CODE ANALYSIS

15 West Street Proposed Residential Board and Care Portland, ME

June 8, 2017

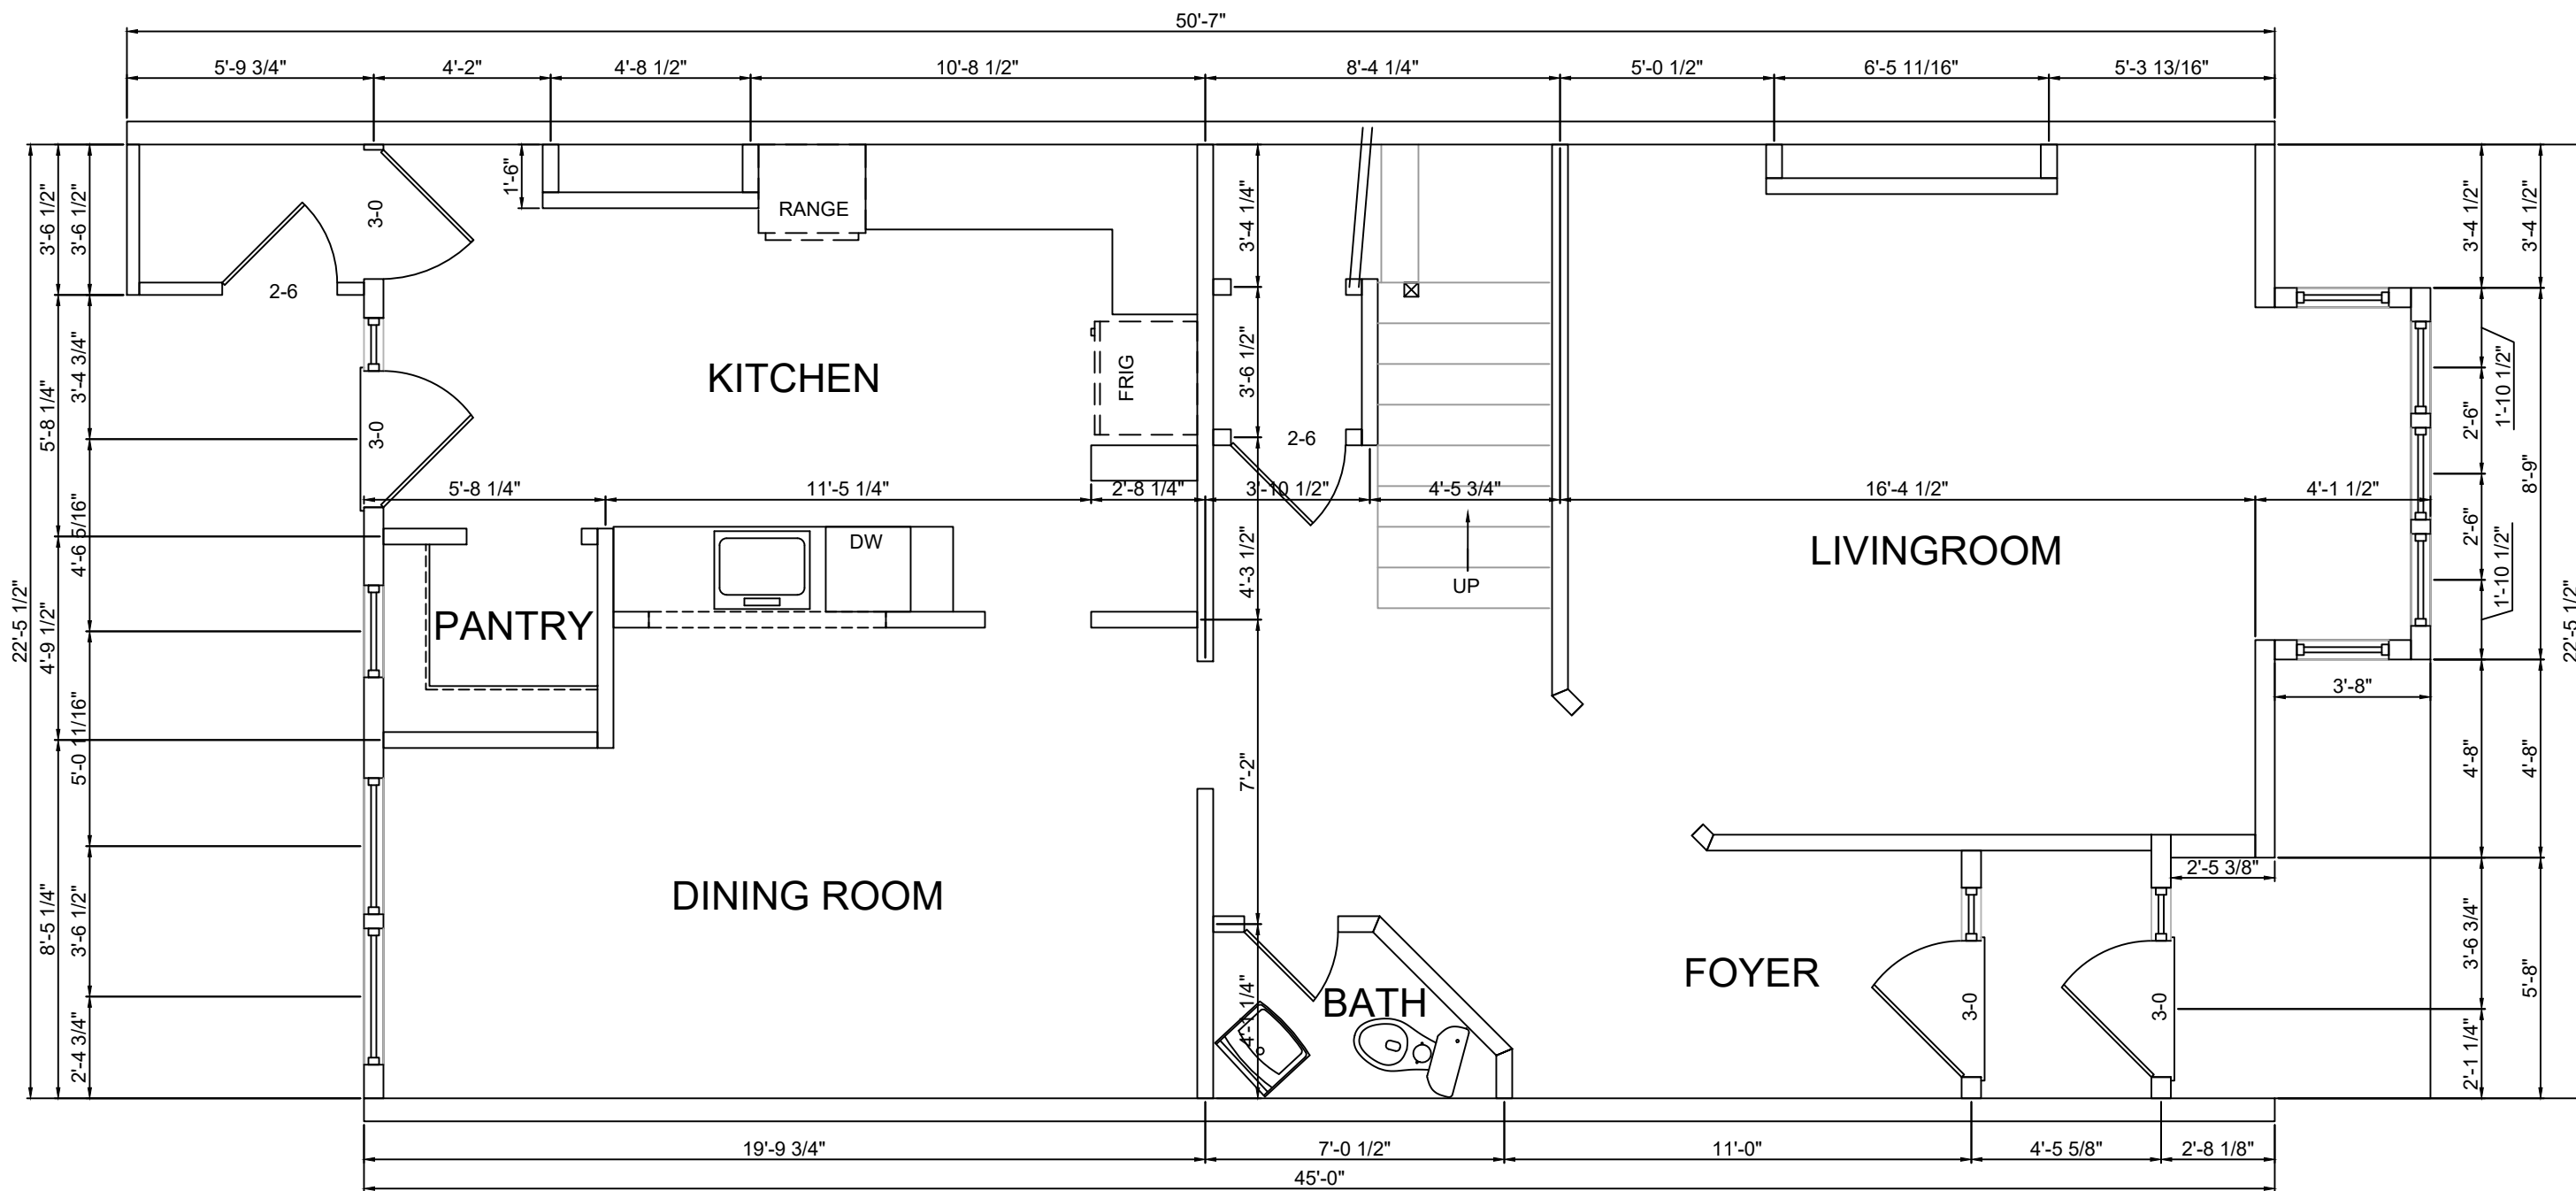
Due to the configuration of the first floor of the subject property, additional automatic closing doors would need to be added at the entrance to the living room and to the dining room, as shown on the attached floor plans (in red). One additional door may be required for floor two (if provisions for automatically closing the existing pocket door are not applied).
